National Infrastructure Planning
Temple Quay House
2 The Square
Bristol, BS1 6PN

Our Ref: EN010082

Application by Sembcorp Utilities (UK) Limited for an Order granting development consent for the proposed Tees CCPP project

Advice following issue of decision to accept the application for examination

Title APPLICATION DOCUMENT REFERENCE No. 4.5  
 INDICATIVE GENERATING STATION PLAN SHEET 3 of 3  
 SCALE 1:2500

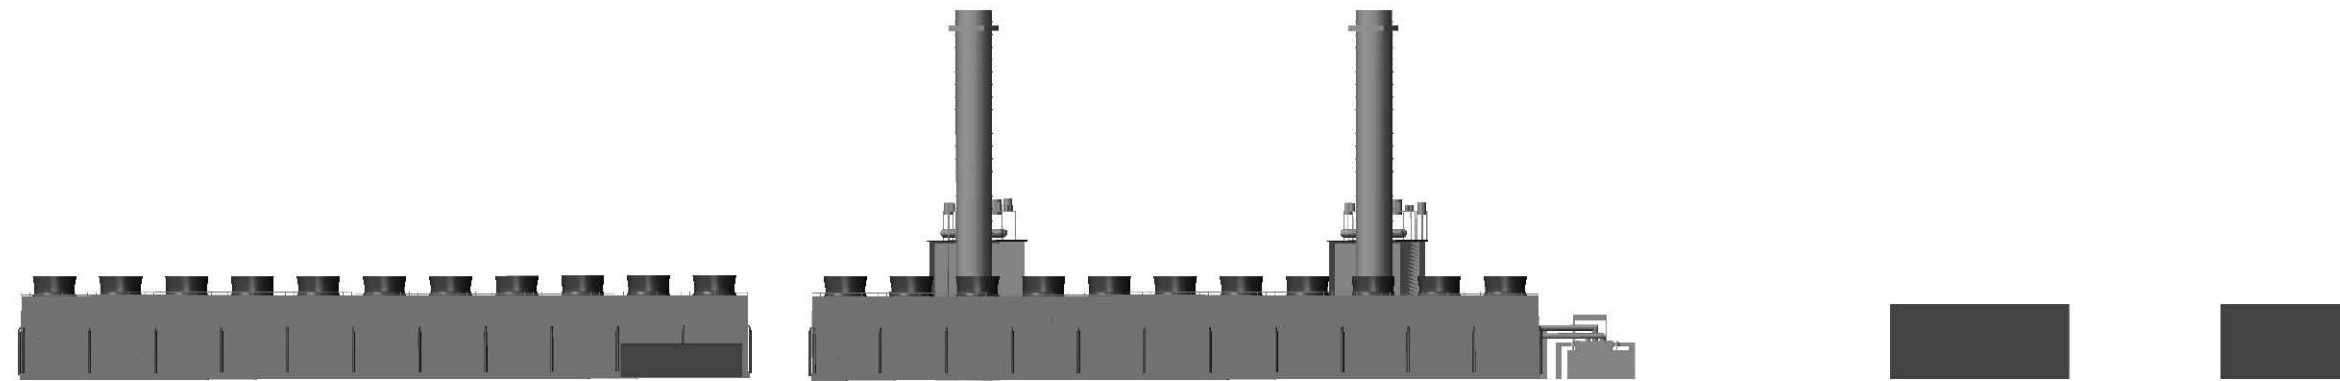
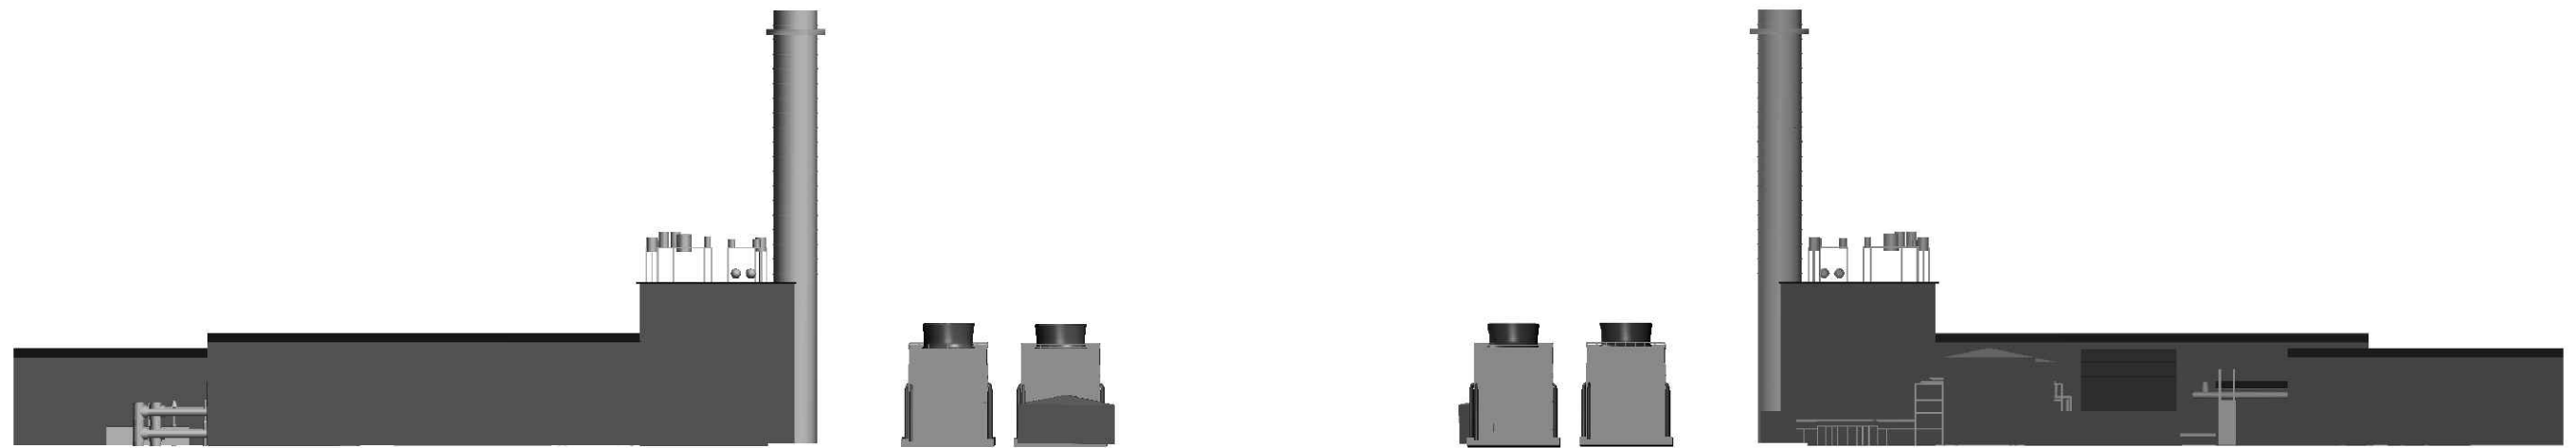
Works Plan (Document 4.5) Sheet 3 which provides elevational drawings does not include a scale bar unlike the plan drawing at Sheet 2 of 3. Whilst Sheet 2 of Document 4.5 would become a certified document should the DCO be made and Sheet 3 would not be certified. Therefore, a scale bar on Sheet 3 would be helpful.
